ENG-MS20001-R1-FDR-redlines Summary_Markup Summary

No. 031901
No. SF-19
MS-20-001

MS-20-001

**DEVELOPED DRAINAGE PLAN (ULTIMATE - FOR INFORMATION ONLY)**

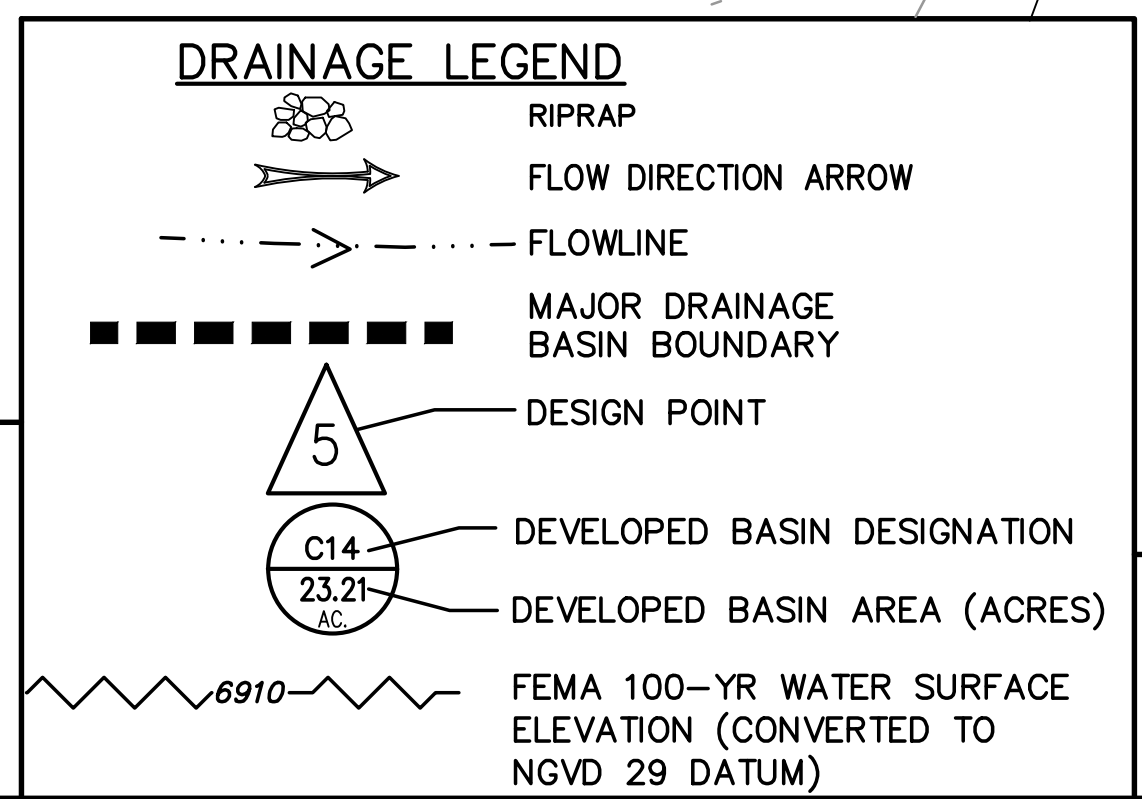
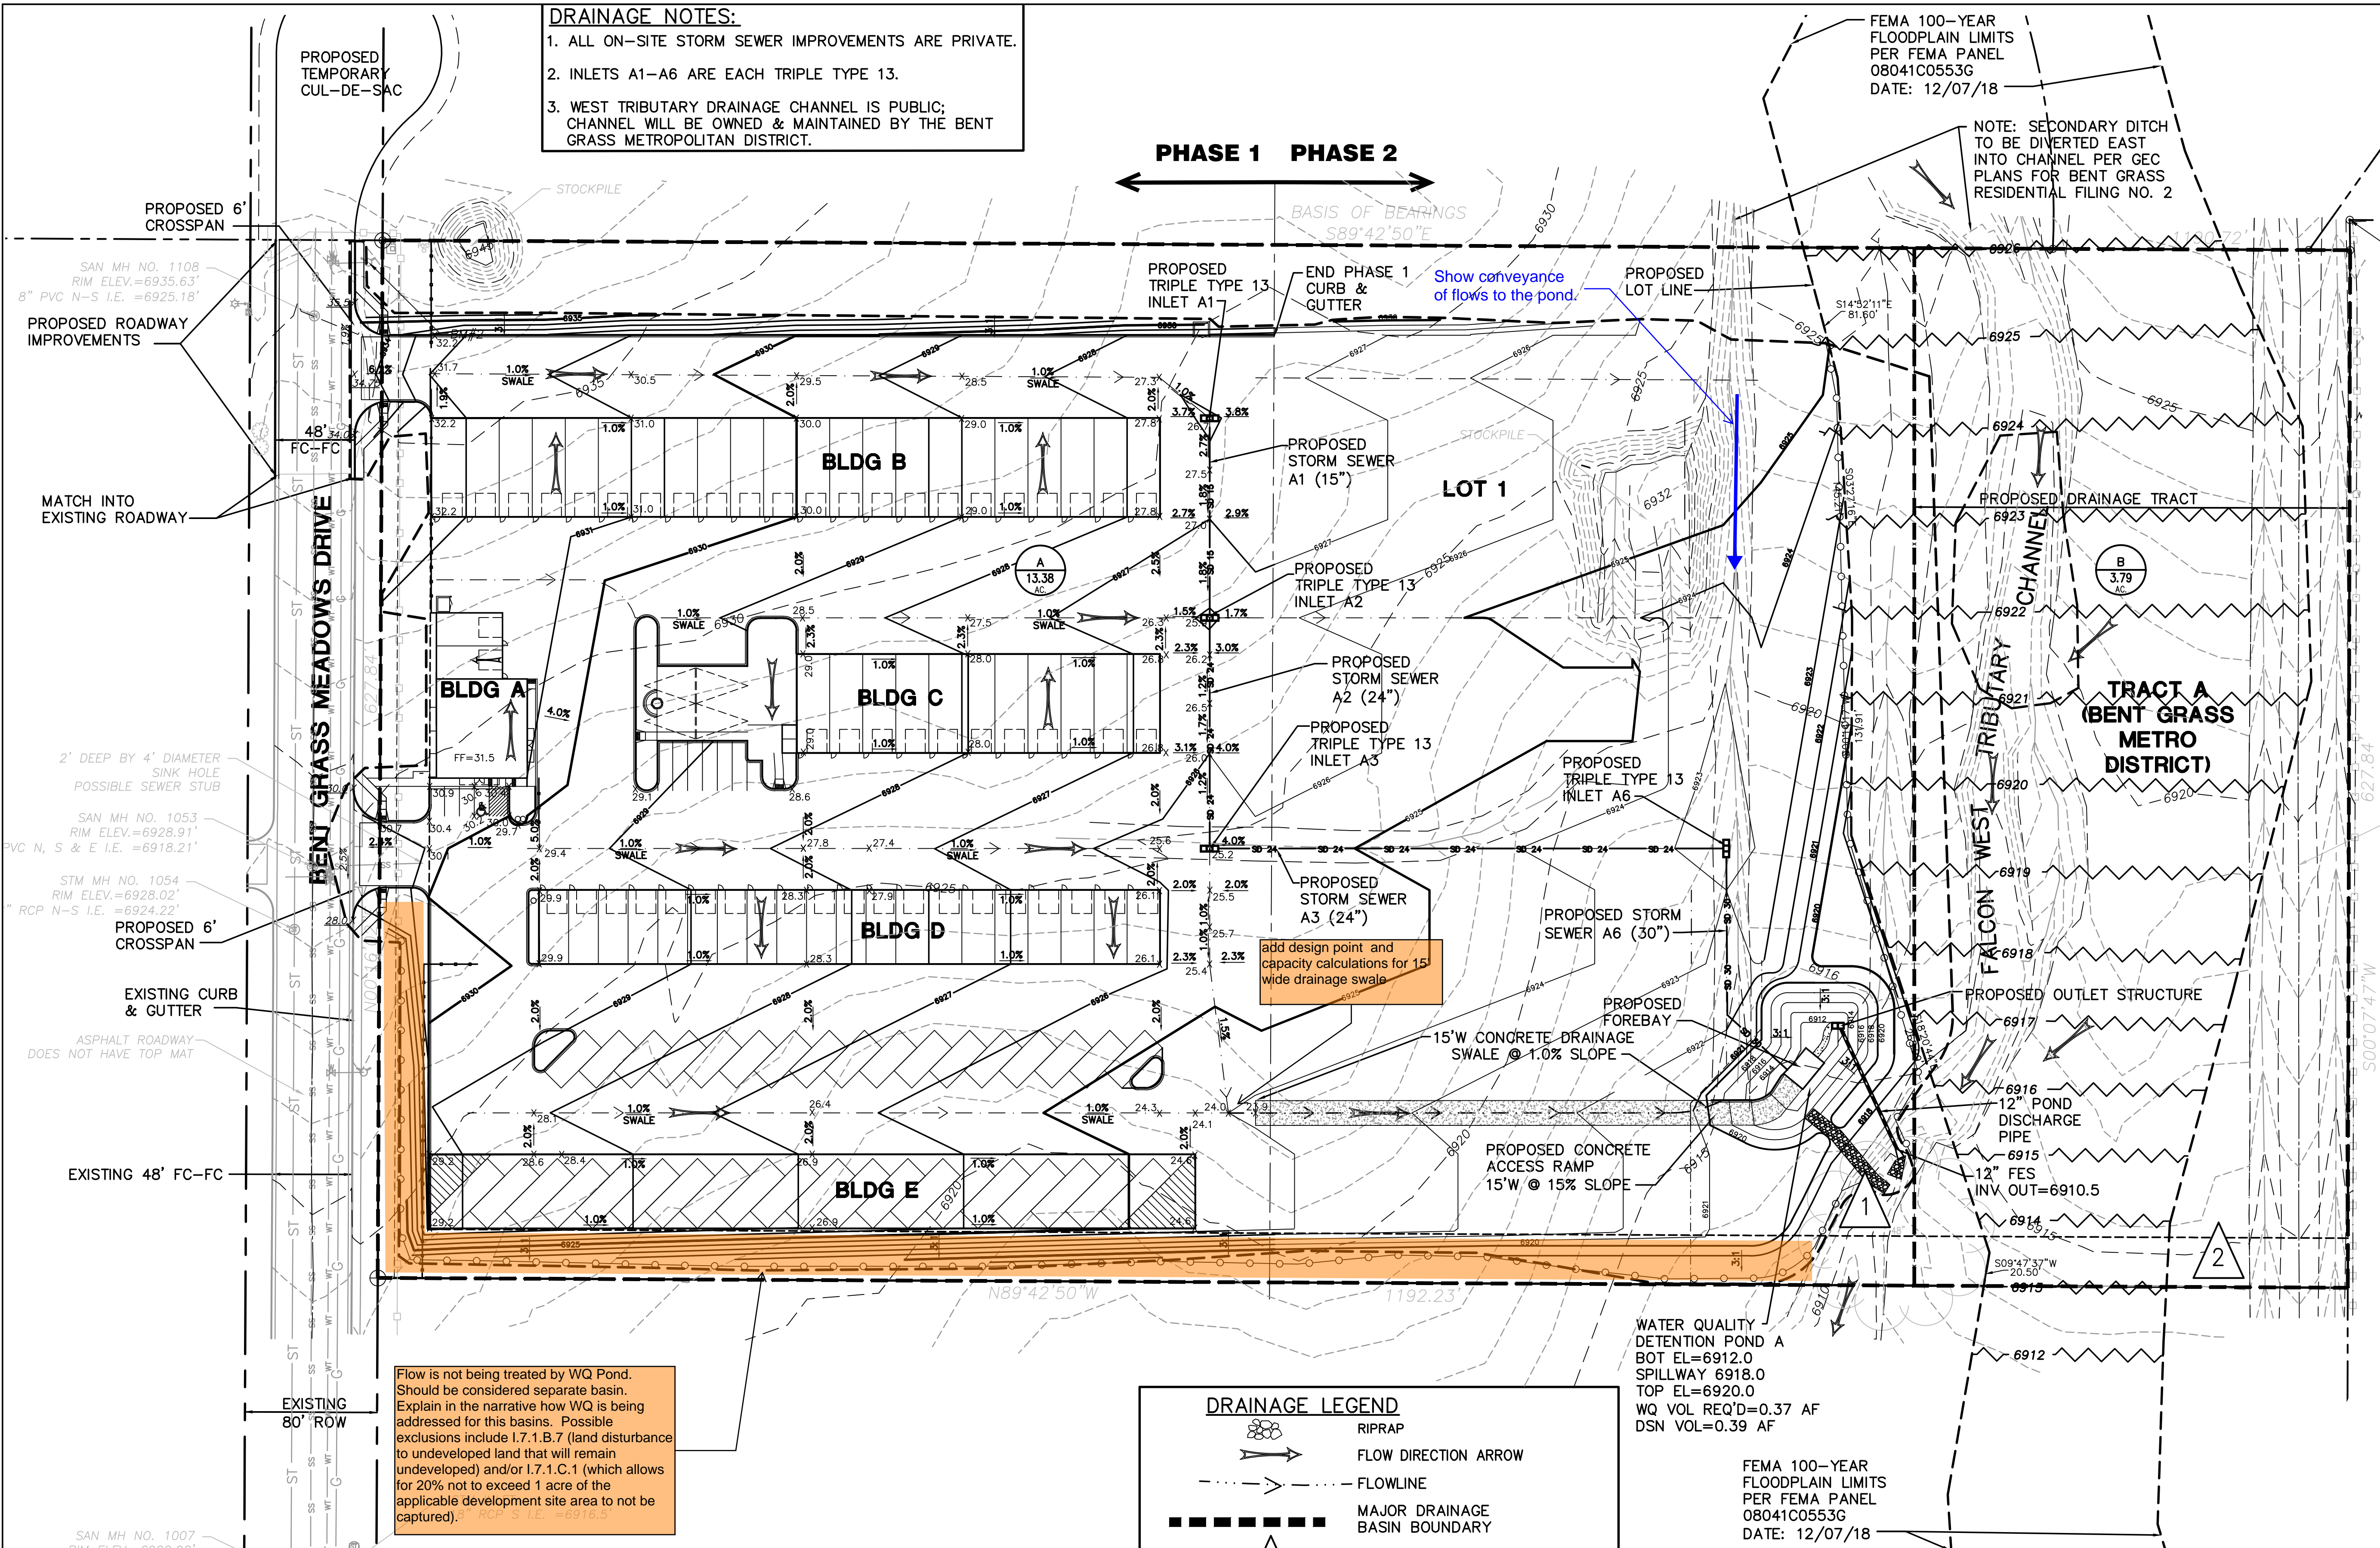
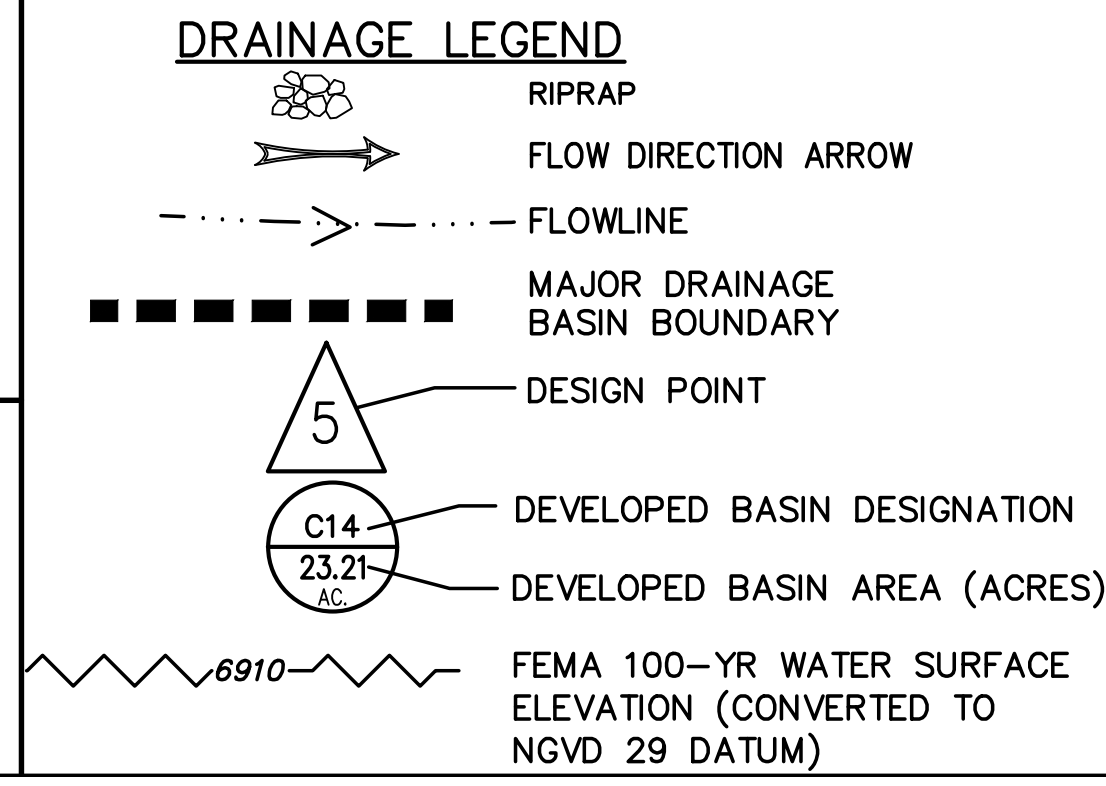
Ultimate (for information only)
